Application for removal or variation of a condition following grant of planning permission.
Town and Country Planning Act 1990.
Planning (Listed Buildings and Conservation Areas) Act 1990

LYNDSEY HAYES REQUESTED SUBMITTING 'VARIATION OF CONDITION' FOR ANNEX STEPS LEADING DOWN TO PROPERTY AS THEY DIFFERED FROM ORIGINAL PLAN DUE TO WORKS CARRIED OUT BY UNITED UTILITIES (2020/2021)

Demolition of existing annex and replacement with new annex including creation of extended car parking area.

Reference number: 3/2020/0407

A1.2 - B

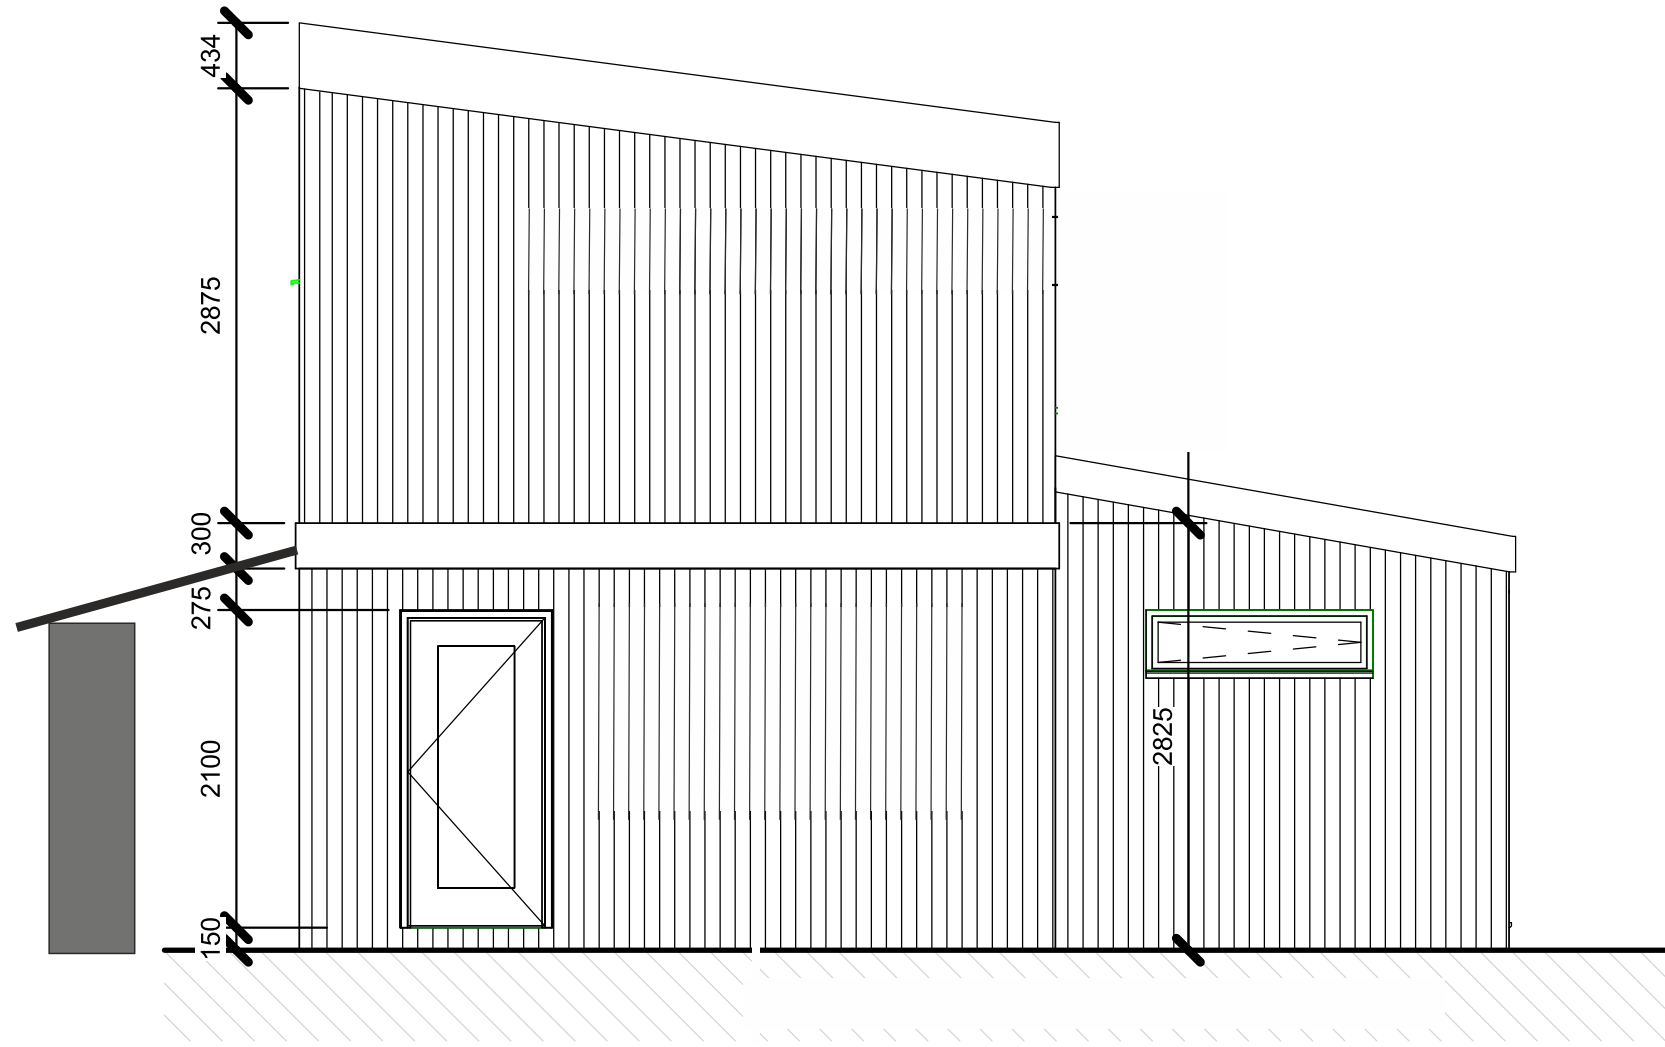
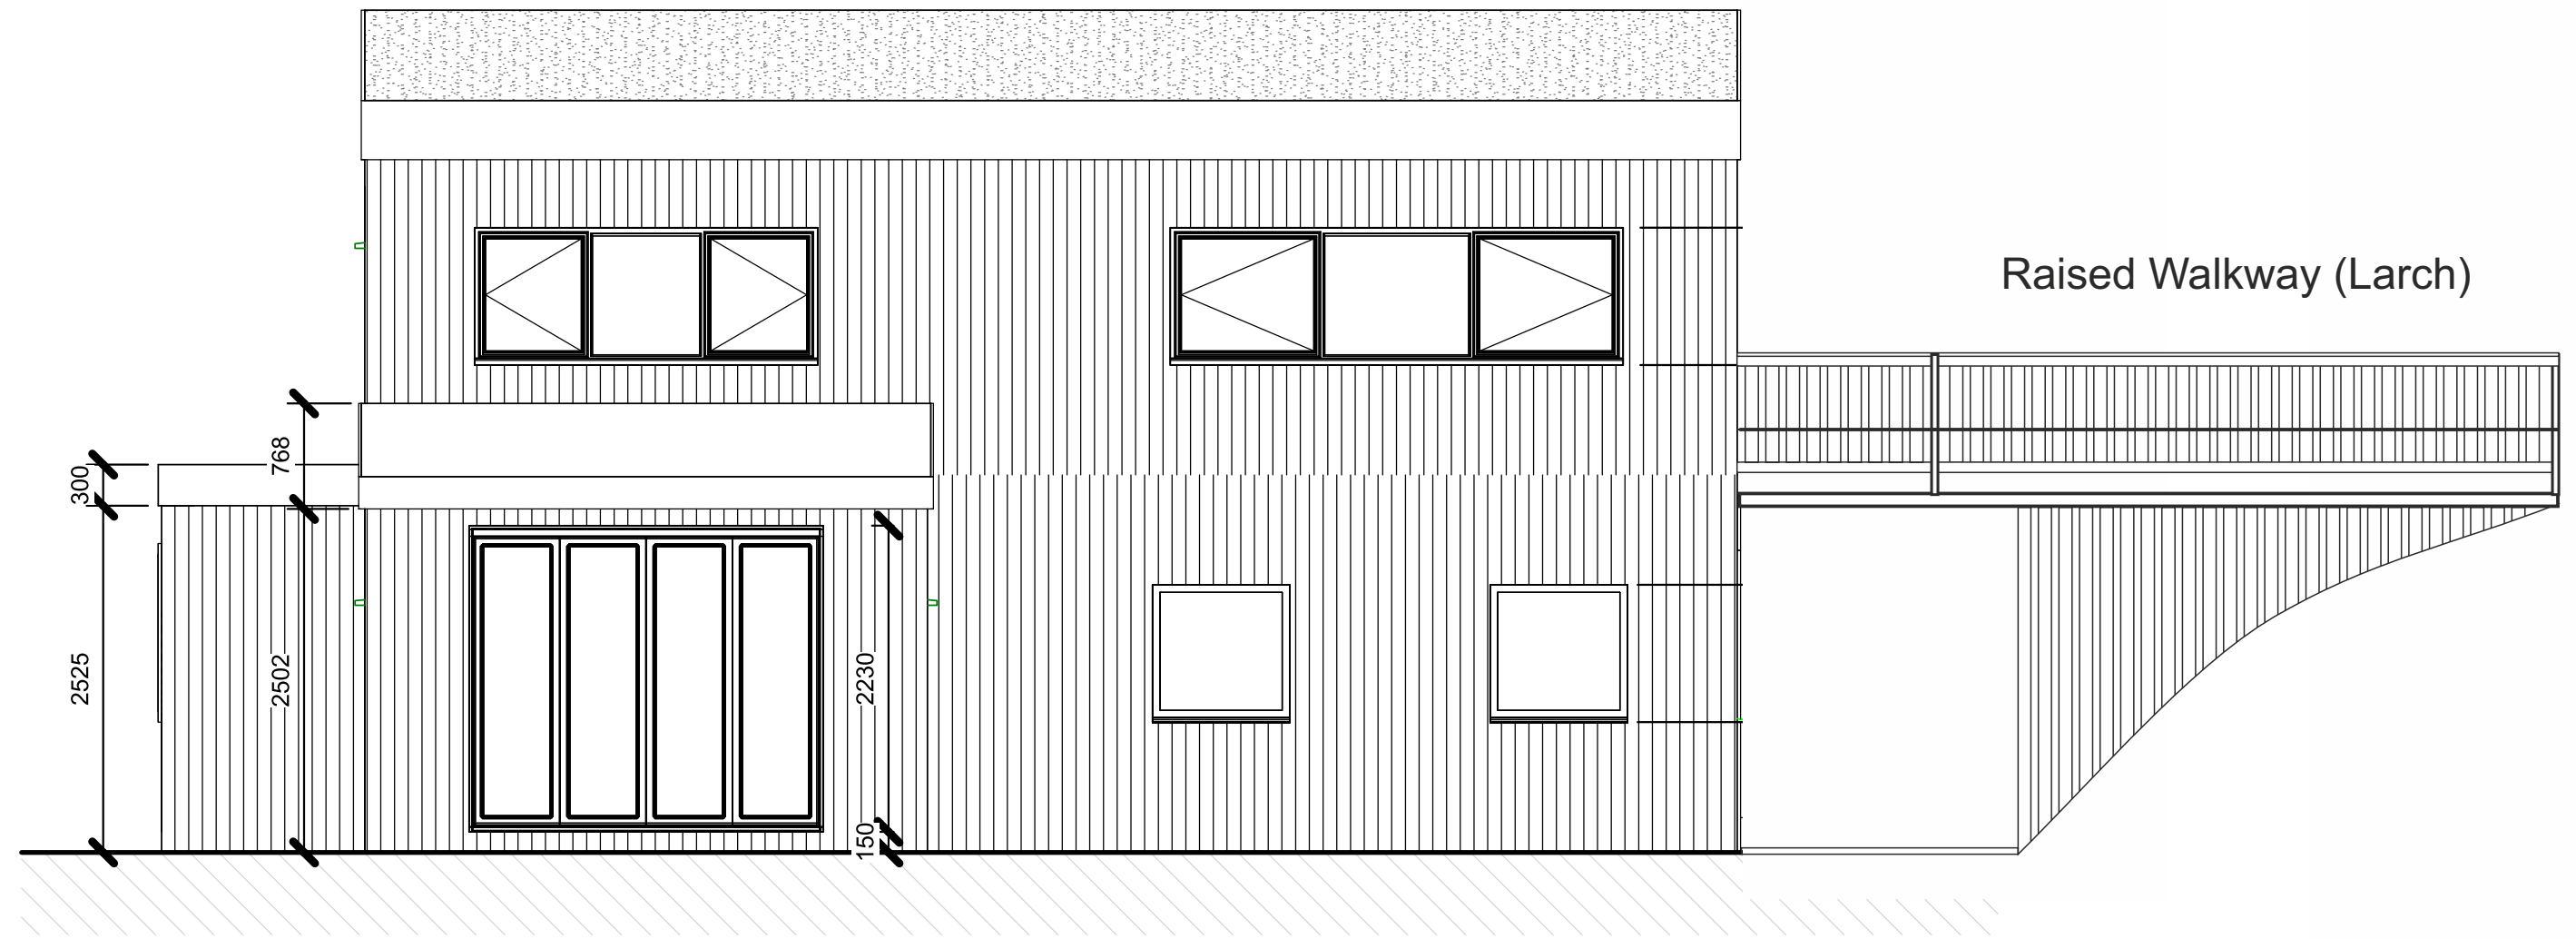
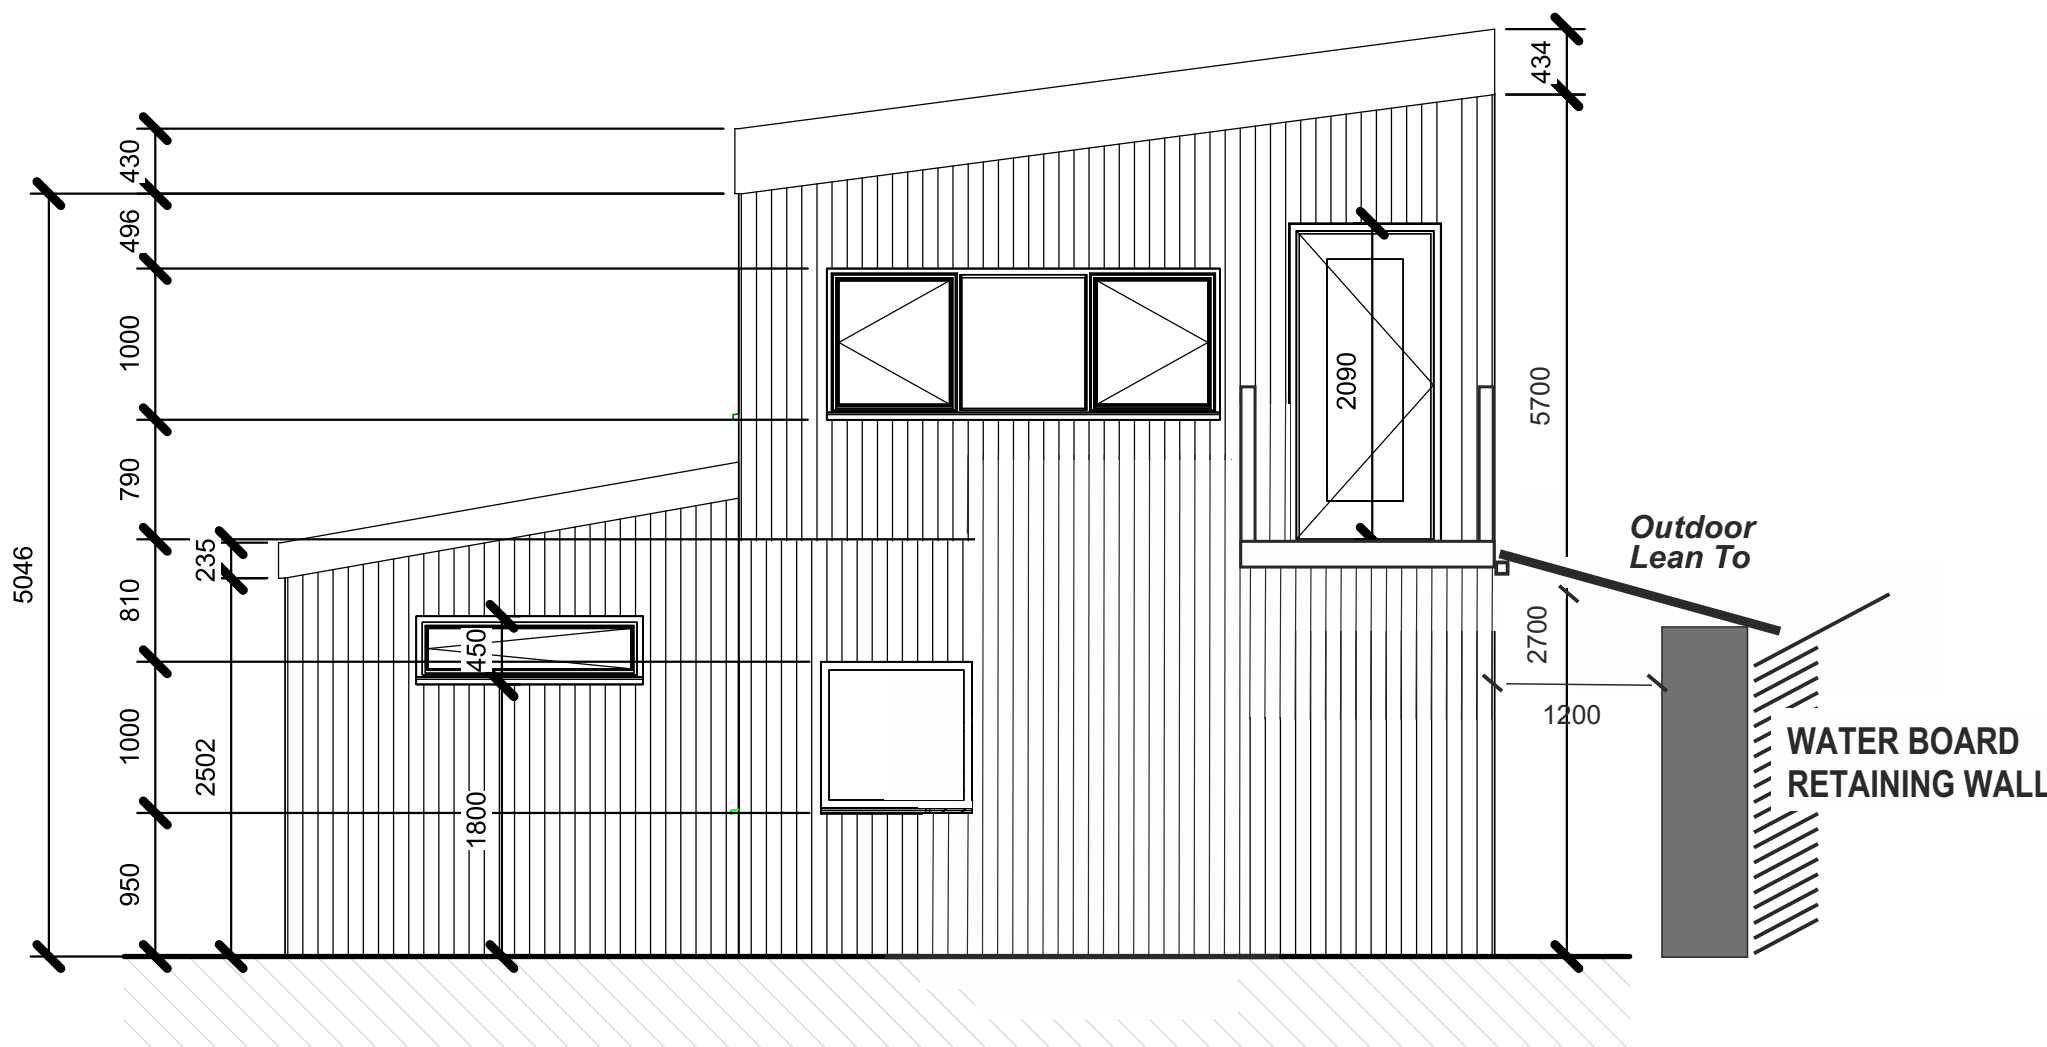
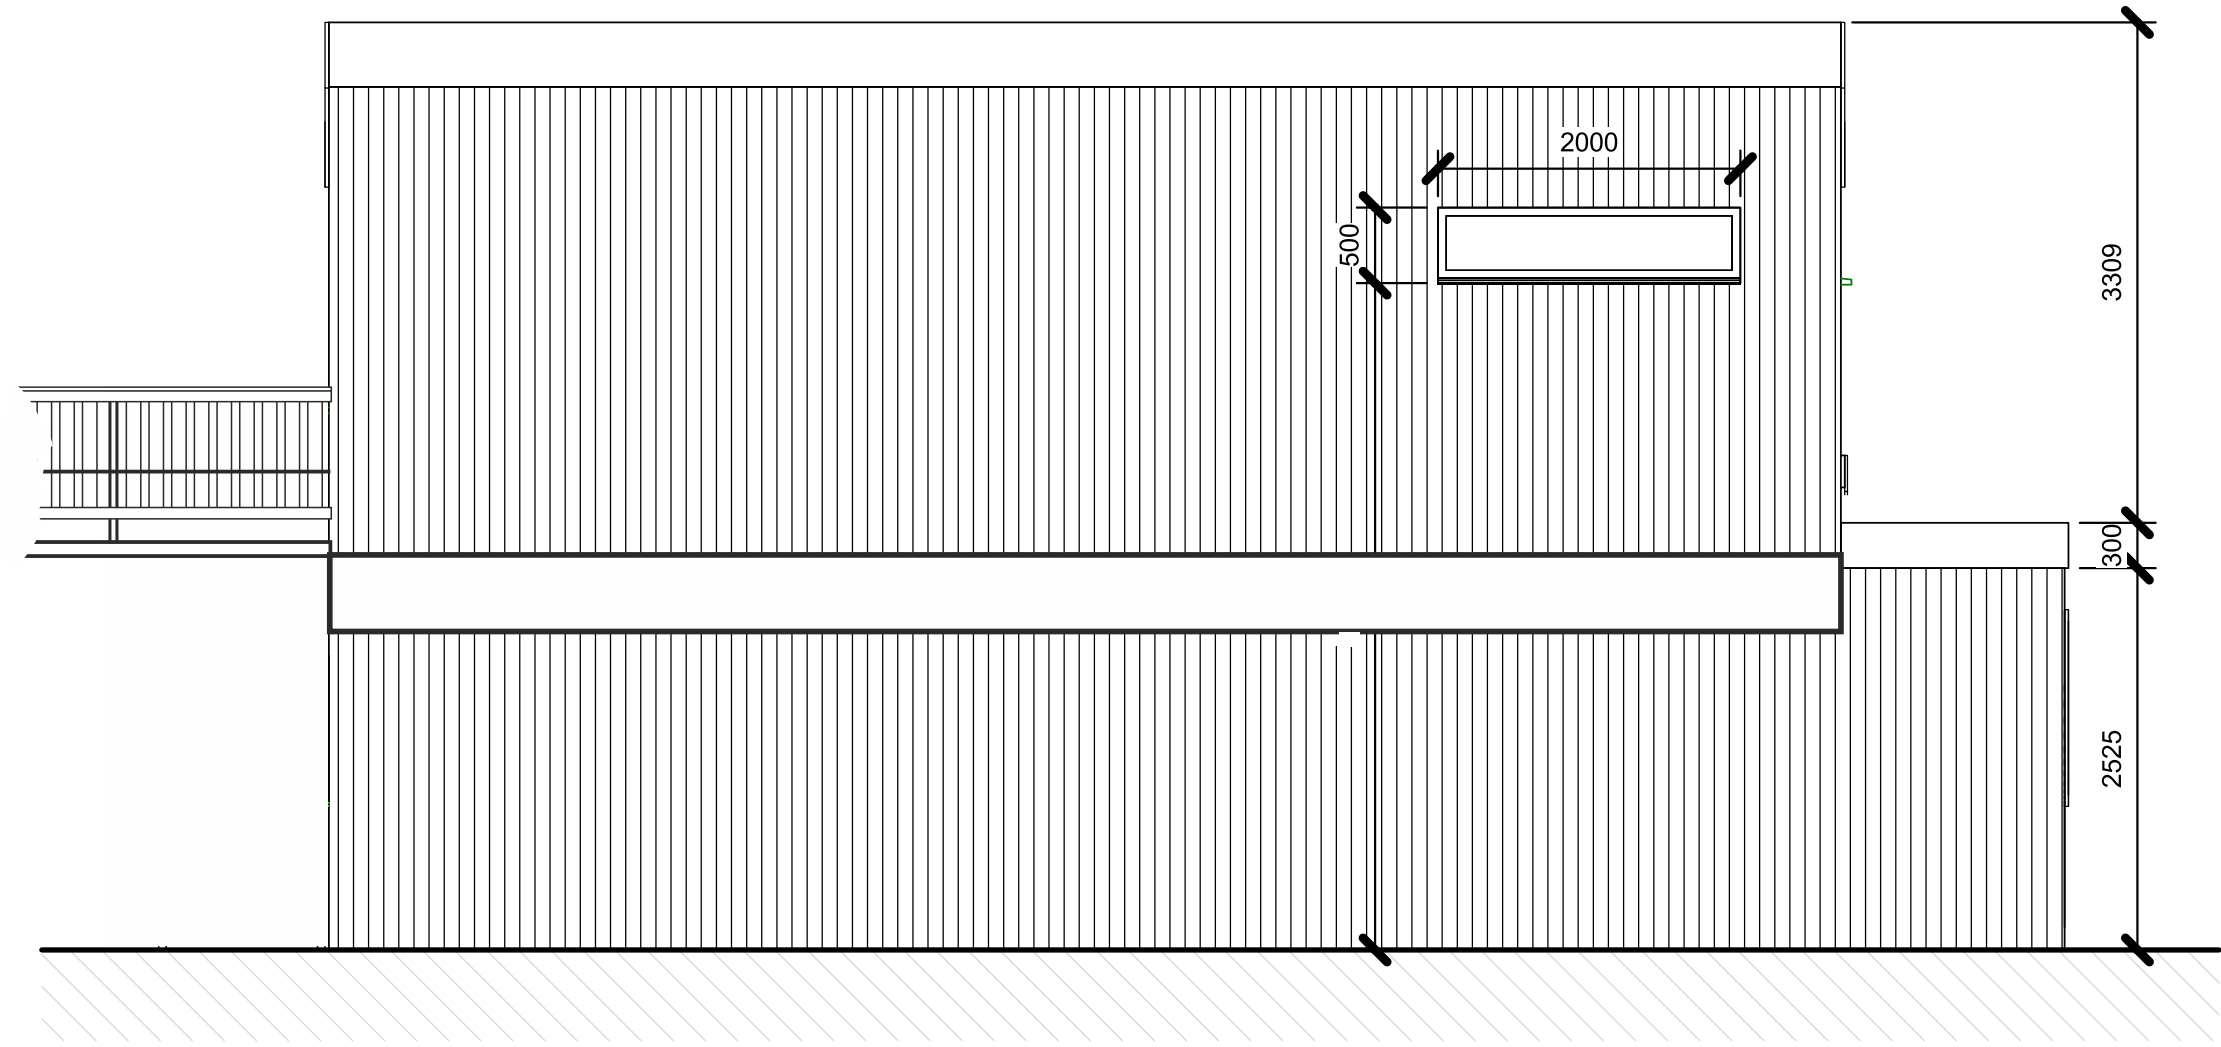
Stairs to the upper parking area (plan "A200 Rev C") could not be constructed due to extensive groundworks by United Utilities in 2020/21 when they had to repair a rising sewer main which runs up the steep bank behind the annex. United Utilities had to build a large 20 metre retaining wall (over 12 feet high) and had to dig back into the bank to access and repair the pipe. The slope became too steep for the planned steps plus any piling and construction of new steps in that area could compromise those repairs.

Due to topography (steep slopes on all sides) and to avoid the rising sewer main (United Utilities repairs) the only option to gain access to the annex from upper parking area is where the steps are located now ... see drawing "A200 Rev D".
